Dáta | Date  
26 April, 2023

Ár dTag | Our Ref.  
TII23-122300

Re. **Strategic Infrastructure Development – Proposed Wind Energy Development including 19 turbines and all associated works at Cloghercor, Co. Donegal**

ABP Case ref. PA05E.316025

Title: Figure 2-3: Turbine Delivery Route

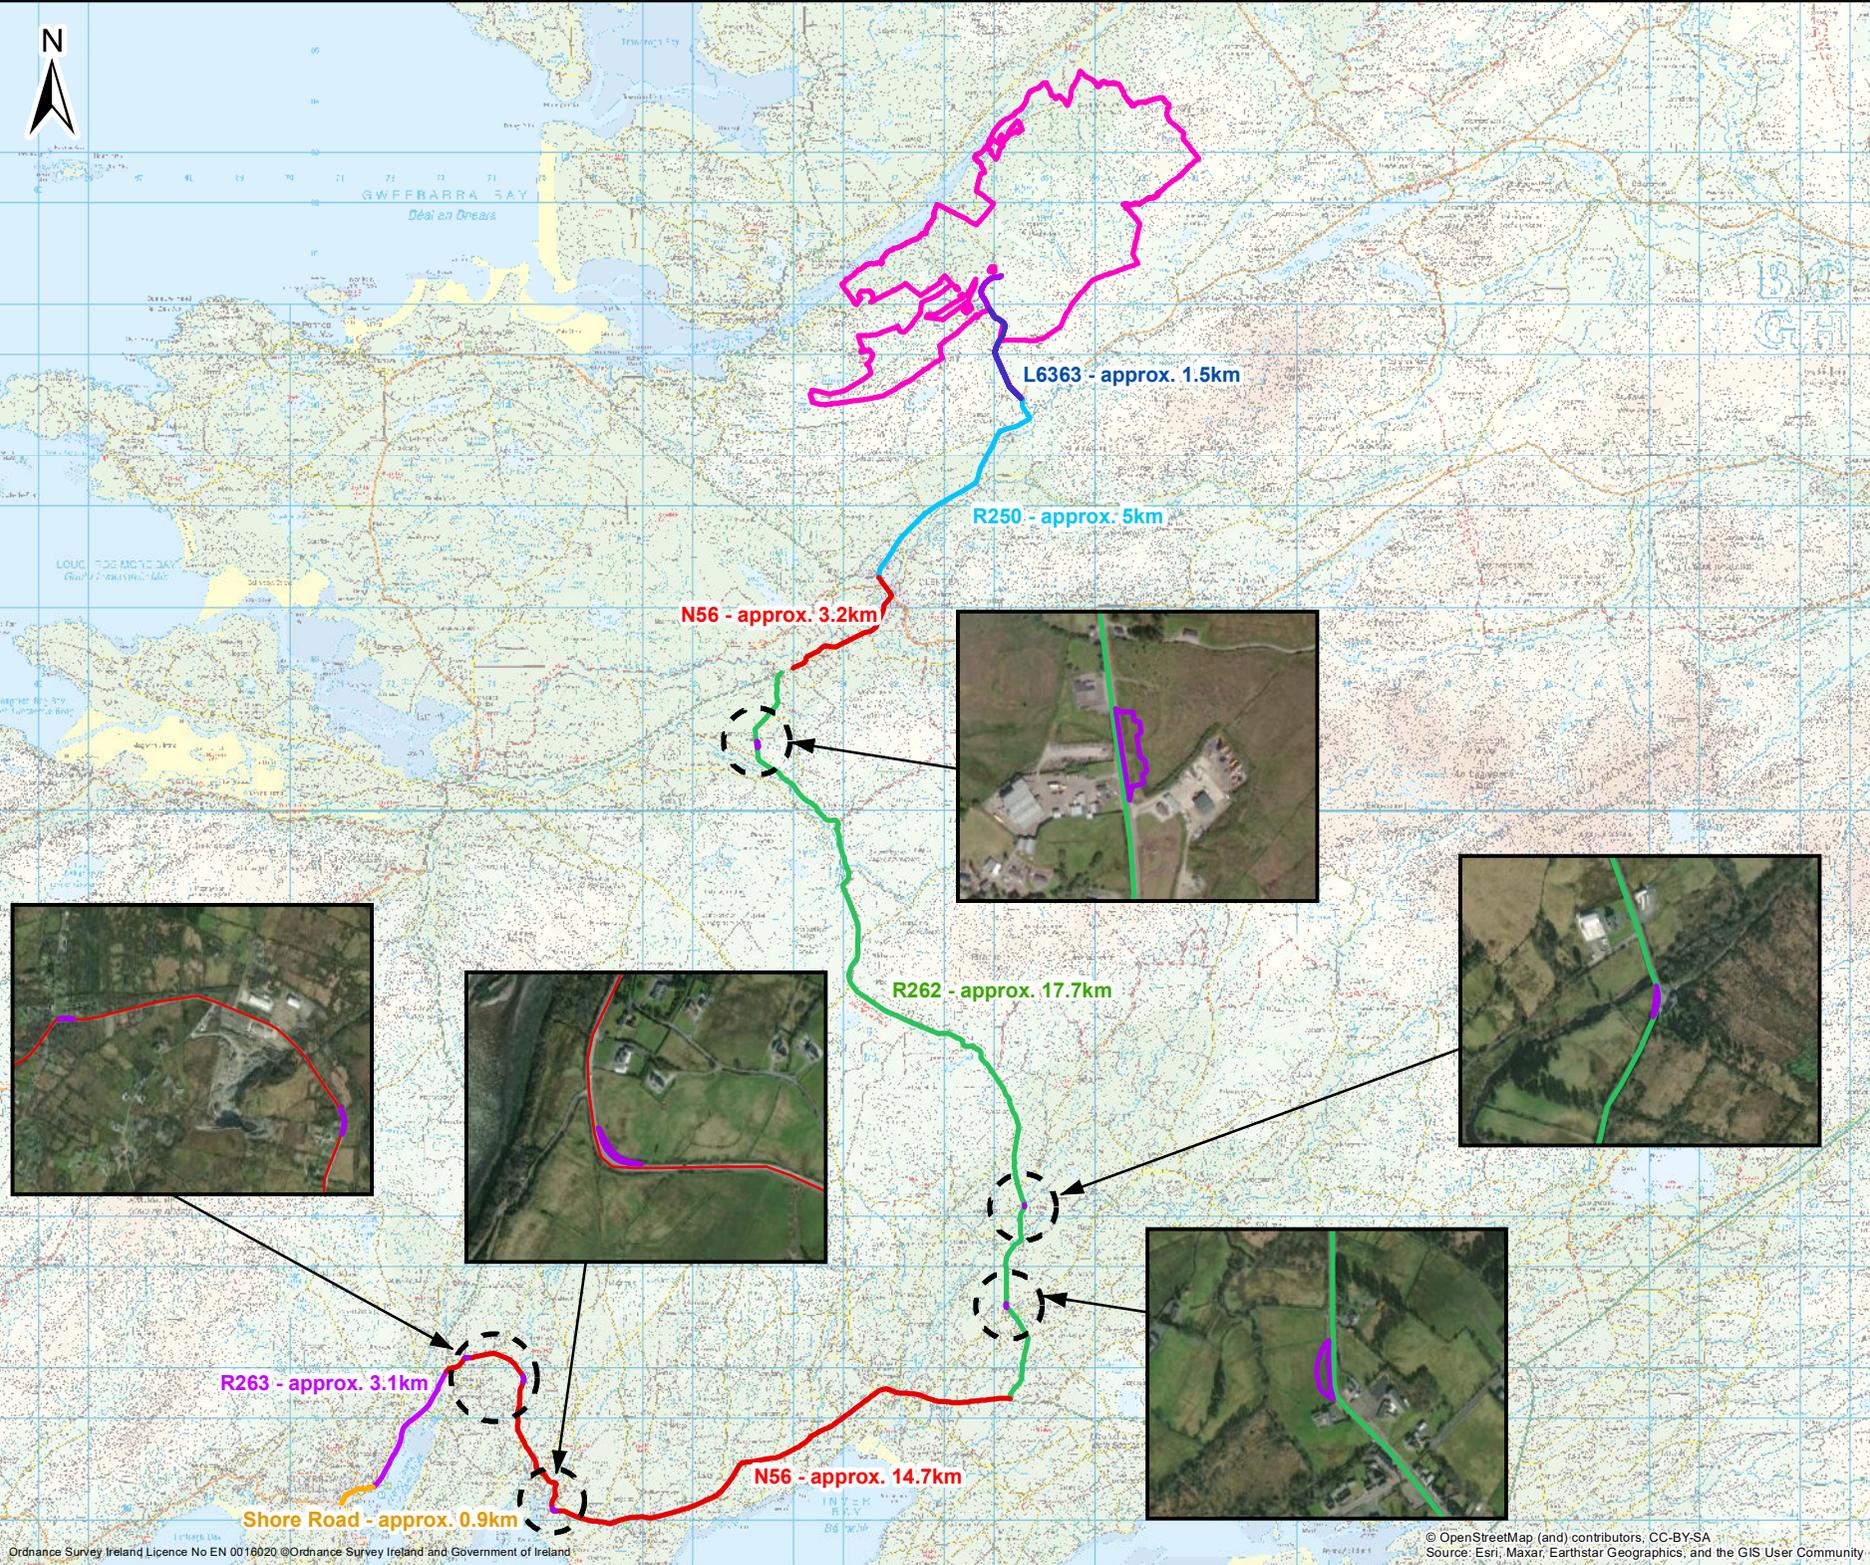
Section 16.7.4 of the EIAR confirms a turbine component haul route from Killybegs to the subject site utilising sections of the N56, national road. Appendix 2.1 details the extent of temporary works required to facilitate turbine component delivery to site.

The proposed haul route is within County Donegal, the applicant/developer should therefore consult with Donegal County Council to ascertain any operational requirements such as delivery timetabling, etc. and to ensure that the strategic function of the national road network is safeguarded.

In the interests of clarification, any proposed works to the national road network to facilitate turbine component delivery to site shall comply with TII Publications and shall be subject to Road Safety Audit as appropriate. Works should ensure the ongoing safety for all road users and prior to any development necessary licenses, approvals or agreements shall be in place.

TII requests referral of all proposals agreed between the road authority and the applicant impacting on national roads. Mitigation measures identified by the applicant should be included as conditions in any decision to grant permission. Any damage caused to the pavement of the existing national road due to the turning movement of abnormal 'length' loads (eg. tearing of the surface course) shall be rectified in accordance with TII Pavement Standards and details in this regard shall be agreed with the Road Authority prior to the commencement of any development on site.

It is unclear if abnormal weight loads are a feature of the application. Any operator who wants to transport a vehicle or load whose weight falls outside the limits allowed by the Road Traffic (Construction Equipment & Use of Vehicles) Regulations 2003, SI 5 of 2003, must obtain a permit for its movement from each Local Authority through whose jurisdiction the vehicle shall travel.

With specific reference to national road structures on the proposed haul route, all structures should be checked by the applicant/developer to confirm their capacity to accommodate any abnormal load proposed.

The Authority has reviewed the EIAR documentation referred and it does not appear that any technical load assessment of structures has been undertaken in support of this proposed application. However, it is acknowledged that abnormal weight loads may not be a feature of turbine or substation component delivery or of the proposed development.

The Authority is of the opinion that an assessment review (by the applicant/developer), where relevant, of all national road structures concerned is required to confirm that all the structures can accommodate the proposed loading associated with the delivery of turbine and substation components where the weight of the delivery vehicle and load exceeds that permissible under the Road Traffic Regulations. The road authority along the haul route should confirm acceptance of proposals by the applicant.
